From: Peter Cleveland
Sent: 31 July 2012 11:48
To: 'Peter Turner'
Subject: RE: The Swan Hotel, Arundel: External Signage and Lighting

From: Lorraine Wilkinson [Lorraine.W@omega-signs.co.uk]
Sent: 20 July 2012 08:24
To: Peter Cleveland
Subject: The Swan Hotel, 27 High Street, Arundel
Attachments: email to highways.pdf; RE: The Swan Hotel, 27 High Street, Arundel BN18 9AG

From: Lisa Coney on behalf of Charlotte Burrows
Sent: 25 June 2012 14:43
To: Lisa Coney
Subject: FW: The Swan, 27 High Street, Arundel - AB/76/12/L
Attachments: LB site plan.pdf

Project Swan Hotel

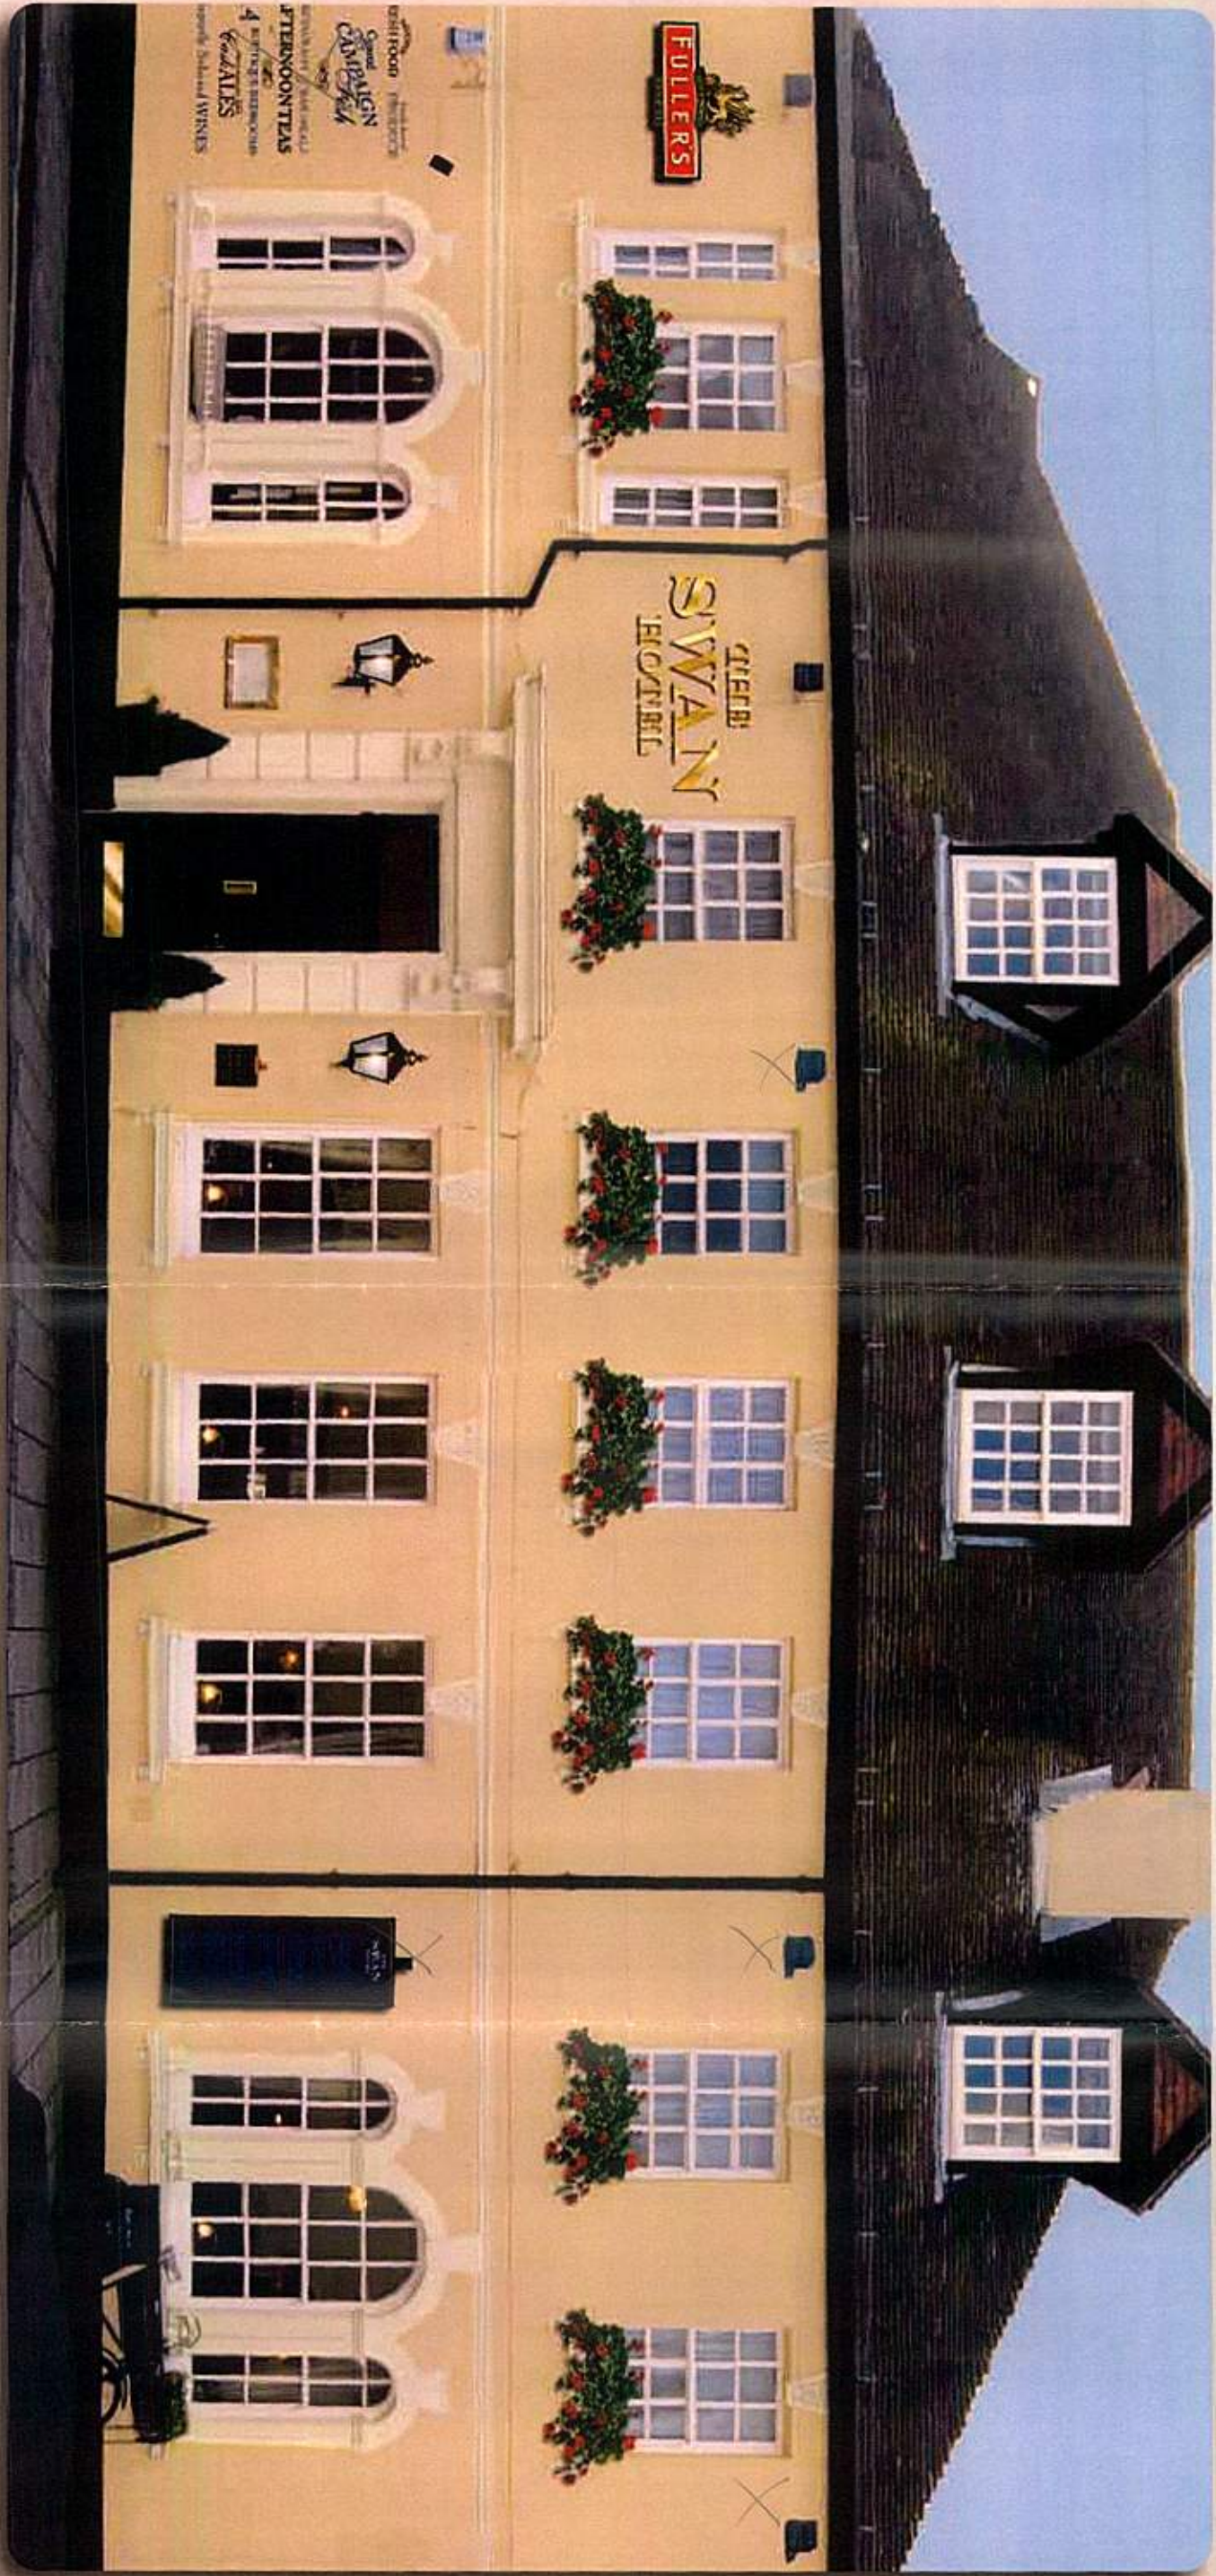
Thank you for the emails below and attachments. I have considered the revisions but I don't think the changes address the initial concerns raised. The revised plans appear to have added further lighting to the building with the design and level of illumination altered and sign written displays still remain. These are ultimately a distraction and detrimental to the character and appearance of the listed building and the wider historic Conservation Area of Arundel. All other advertisements approved within the locality are sympathetic and in-keeping the historic High Street. The sign written displays and over illumination should be removed from the proposal to gain a positive recommendation.

I have collaborated with Omega Signs in designing a revised scheme, addressing the points made to you by the planner.
Perhaps you could show the revised scheme to Peter Cleveland for his guidance before Omega submit a new application?

We intend to wash the walls with a soft, warm light from low energy fittings. The signs will be picked out in brighter white light.
All the fittings under the eaves will be painted to match the walls – making them so discreet that they will not be noticeable.

Note that we propose to position a lantern above each of the panels of sign-writing in place of spotlights.

In the revised scheme the panels of sign-writing are much smaller and a good deal more restrained in design. The typography in simple black has an elegant 18th century feel in keeping with the architecture. As an alternative, another attachment shows how the messages could appear in the form of a separate amenities board. We prefer direct sign-writing, but would be happy with either approach. As a fall-back position, blackboards would be better than nothing.
